REQUEST

Approximately 4.62 acres located at the northeast intersection of Harwood Lane and Mt. Holly-Huntersville Road, west of Country Lane.

SUMMARY OF PETITION

Staff recommends approval of this petition.

# RZ-1.0

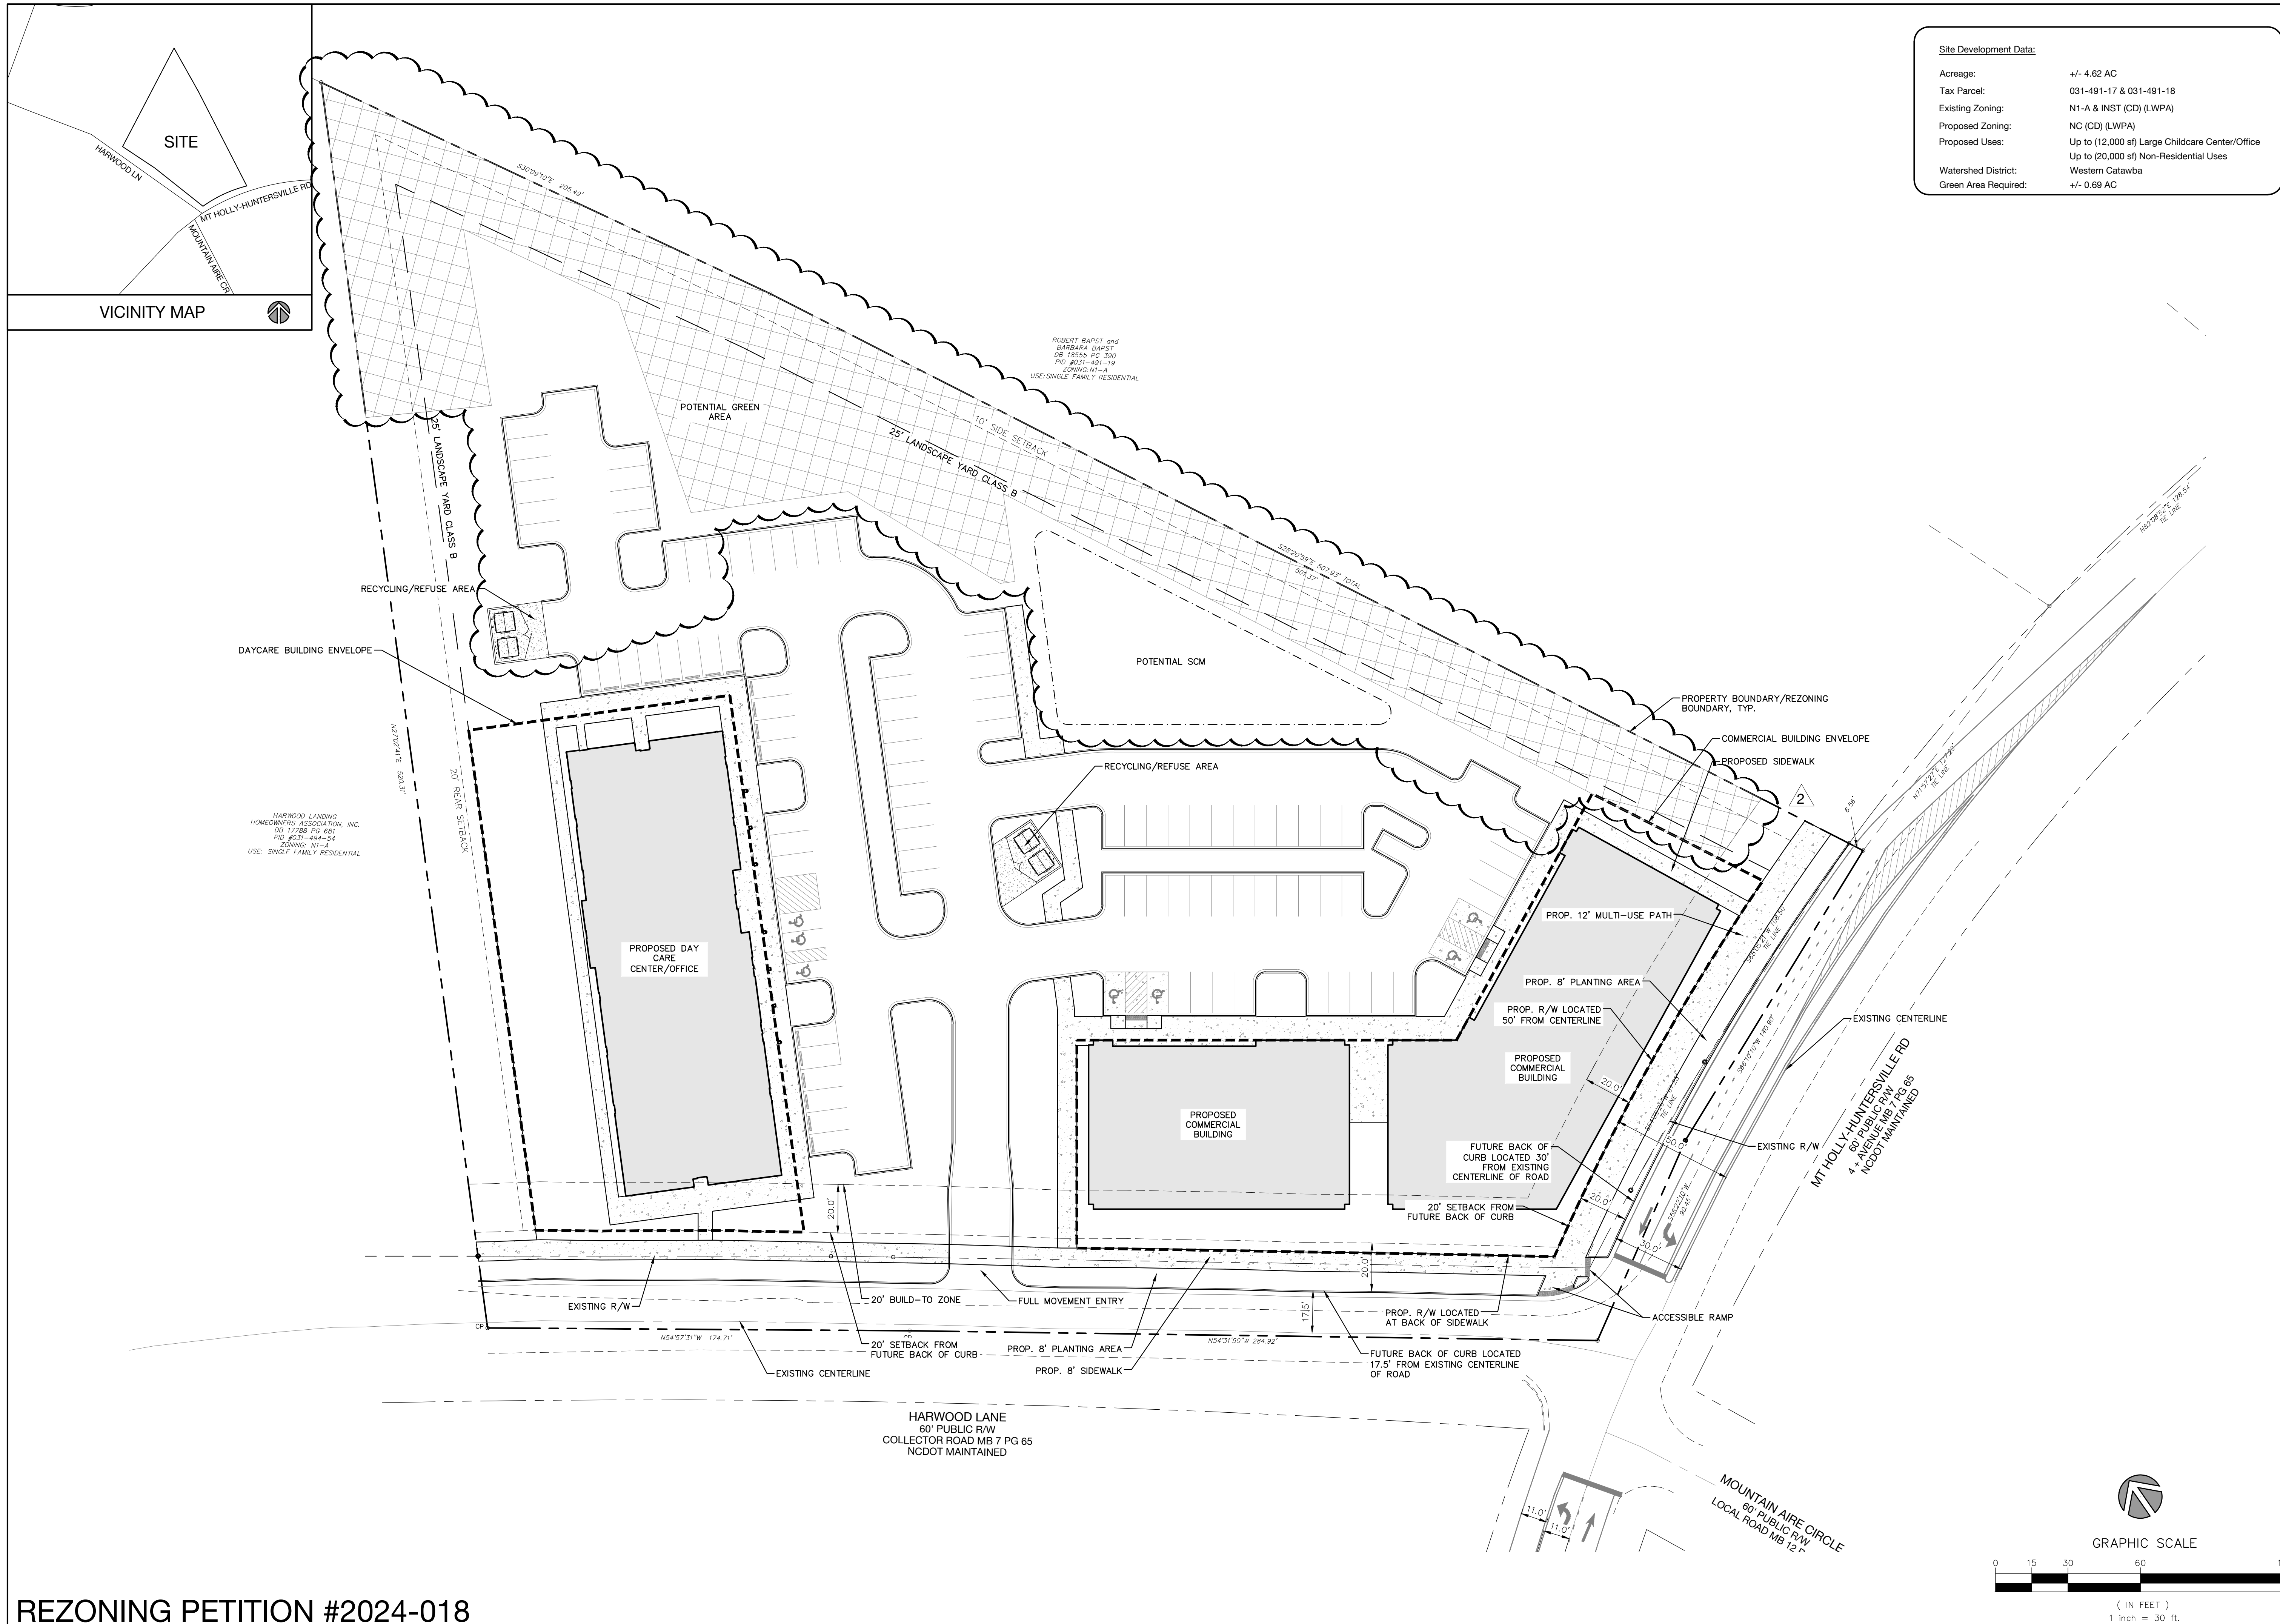
2. ~~Urban Forestry: Green area shown does not meet standards. A large section of what is being shown a protected tree canopy does not have any trees.~~ **ADDRESSED**
3. ~~Tree Survey for Conditional Zoning Map Amendment. A tree survey shall be required for all conditional zoning map amendments.~~ **ADDRESSED**
